Harnett County Government Complex
307 Cornelius Harnett Boulevard
Lillington, NC 27546

April 11, 2008

**Re: Status of Improvement Permit Application #08-5-19824
Persimmon Hill Lt 18**

Wm. Kent Pierce Inc.
Lot # 18 Persimmon Hill
210 Old Field Loop

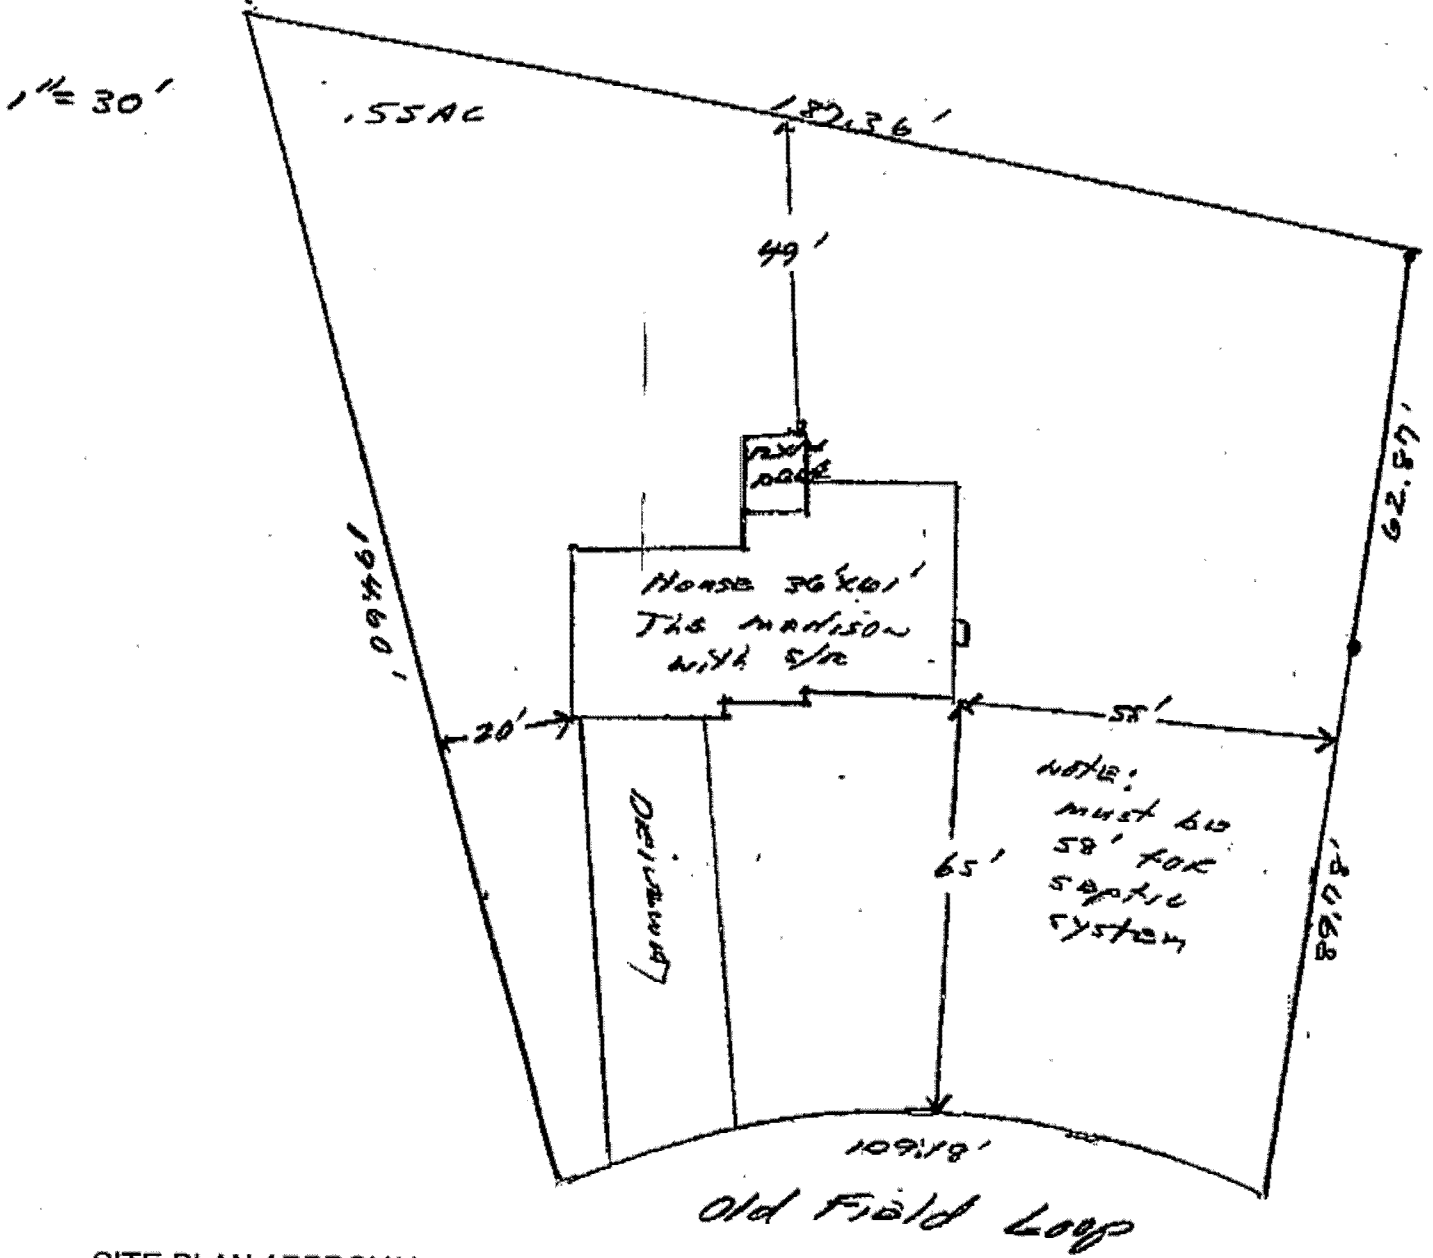
- 1. Property lines/corners not marked or labeled
- 2. House corners not marked or labeled
- 3. Directions not clear to property
- 4. Property needs brush or vegetation removed
- 5. Backhoe pits required
- 6. Other - **Move home as shown and submit new plot plan to Central Permitting and reconfirm.**
(Please note change in garage and drive location).
